MORGAN AND MORECAMBE OFFSHORE WIND FARMS: TRANSMISSION ASSETS

Street Works Plan- Part 2 of 2

22 September 2025
Rev: F03

Schedule of Changes

Drawing Title:
 Street Works Plan - Sheet 12 of 19
 AFPF Reg: 5(2)(k)
 Document Reference: B12

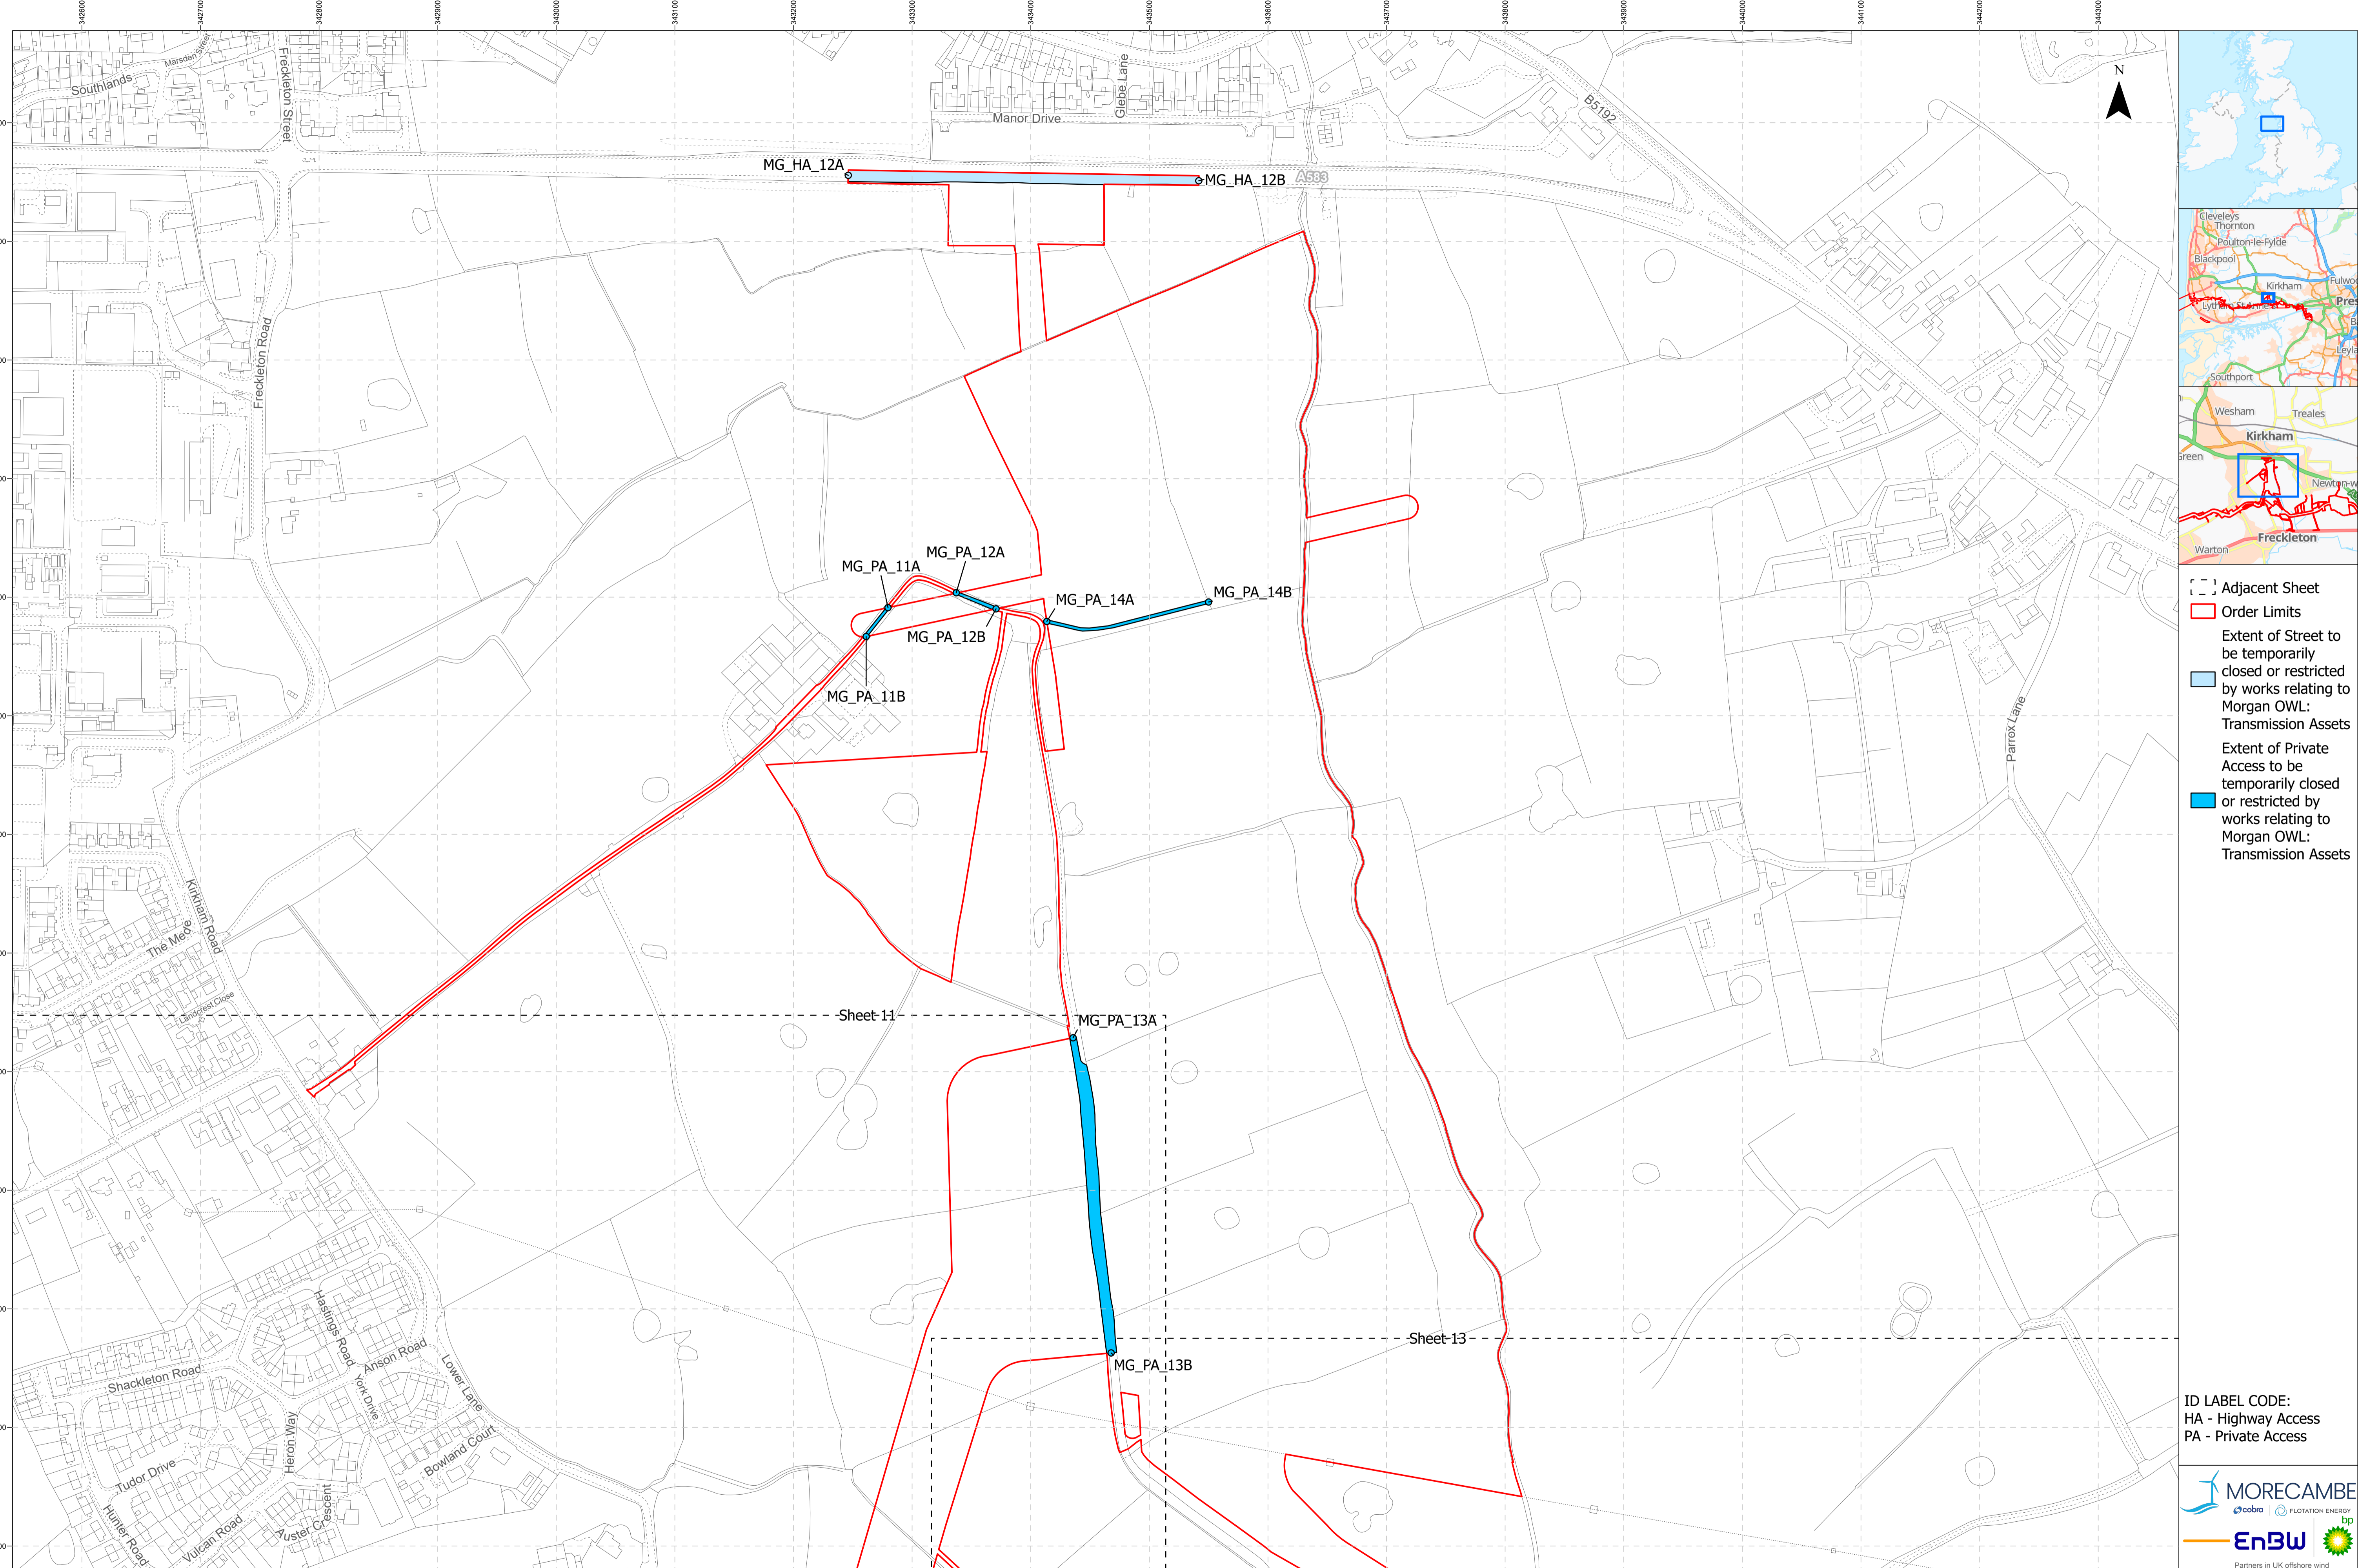
Sheet Number	Change requested by	Change Made	Reason for Change	Revision	Submission deadline
1	Blackpool Borough Council	Removal of extents on Squires Gate Lane between points MGMC_HA_1A and MGMC_HA_1B; Private Access between points MGMC_PA_1A and MGMC_PA_1B; and on Squires Gate Lane between points MGMC_HA_35A and MGMC_HA_.	To address points raised in discussion with Blackpool Borough Council via the Statement of Common Ground process to remove powers within the draft Development Consent Order (document reference C1) associated with Starr Gate and the access into Blackpool Airport via Squires Gate Lane.	F02	Deadline 4
5	The Applicants	The labelling of MGMC_HA_10A has been moved to ensure the entire reference is visible	A review of the Street Works Plan identified that the label was partially hidden by the inset box and therefore was moved to ensure full readability.	F03	Deadline 5
